OUT19/14362

Modification 2 to New Tweed Valley Hospital (SSD-9575)

DPI has reviewed the modification and has the following comments and recommendations.

SOUTH-EAST ELEVATION - CAR PARK
SCALE 1:2000

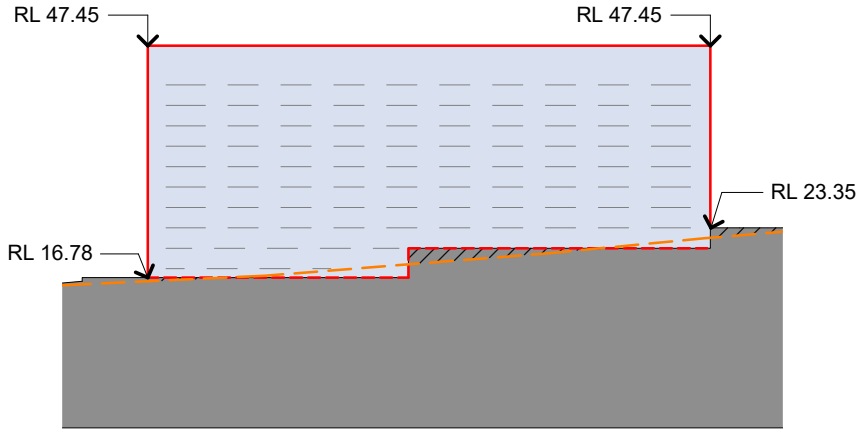
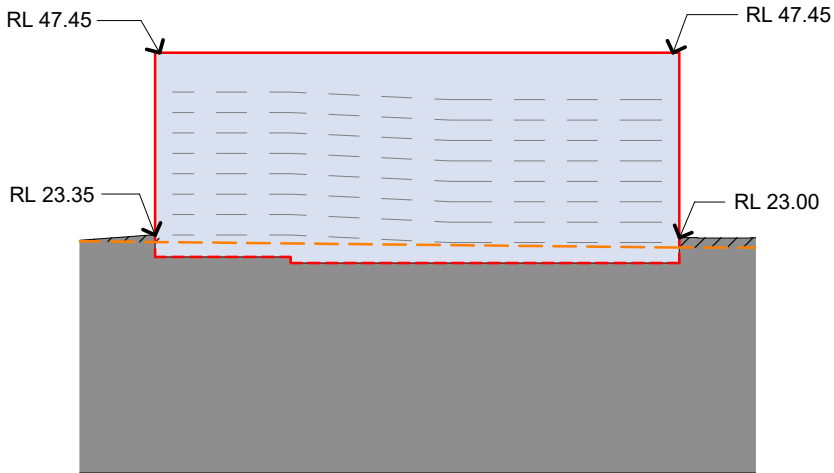
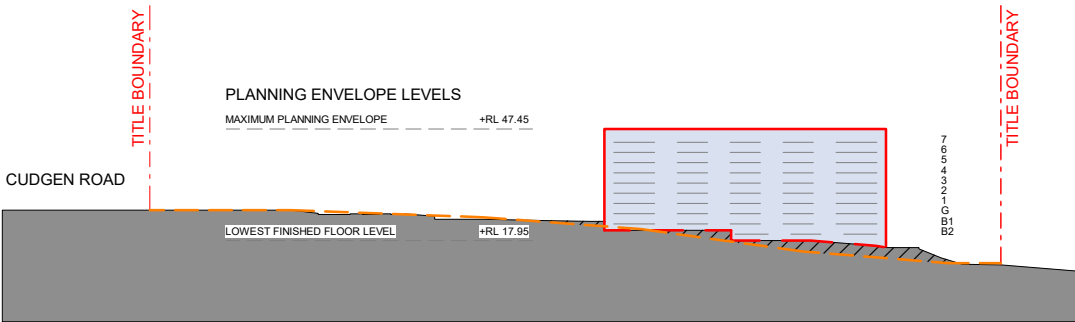
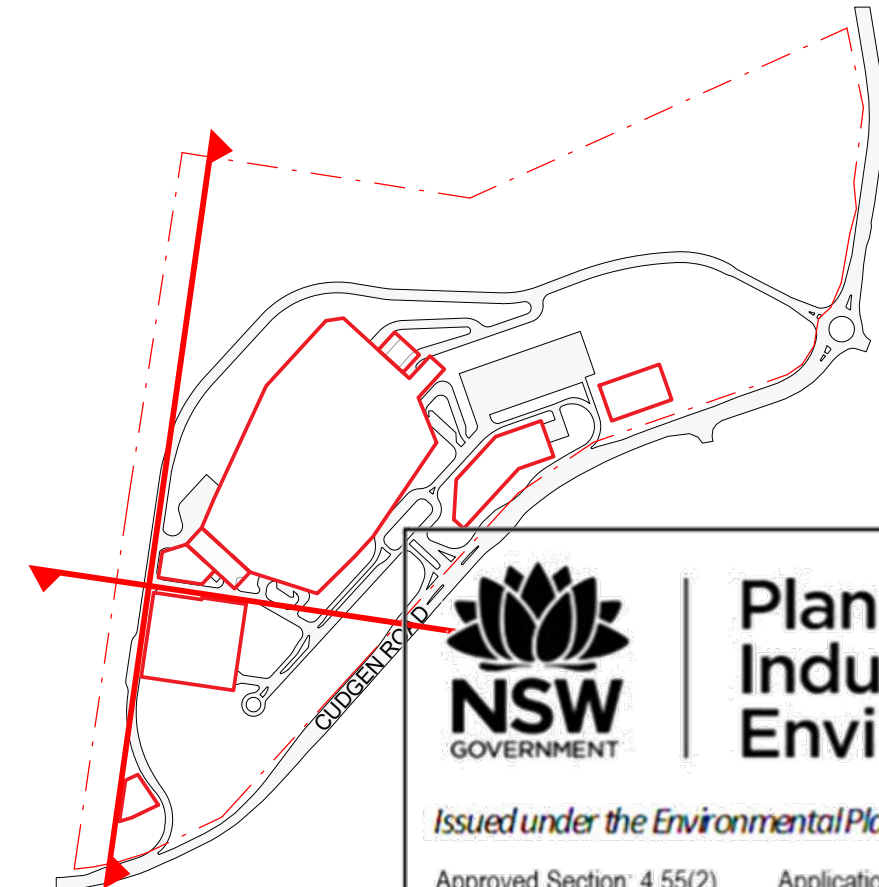
DPI notes the proposed modification for a multi-deck car park on the western boundary of the hospital development. As indicated the condition of consent requires a 10m vegetated buffer along the western boundary which will not be altered as a result of this modification. The previous concept plan allowed for the potential to increase this buffer to between 22-30m should future intensification of agricultural production occur on the adjoining land. It is understood that the inclusion of the multi-deck car park will reduce this potential distance for part of the western boundary.

As such, DPI recommends that consideration be given to include some form of screening within the car park design that will assist with reducing any potential land use conflict risk with agricultural activities on the adjoining land parcel in the future.
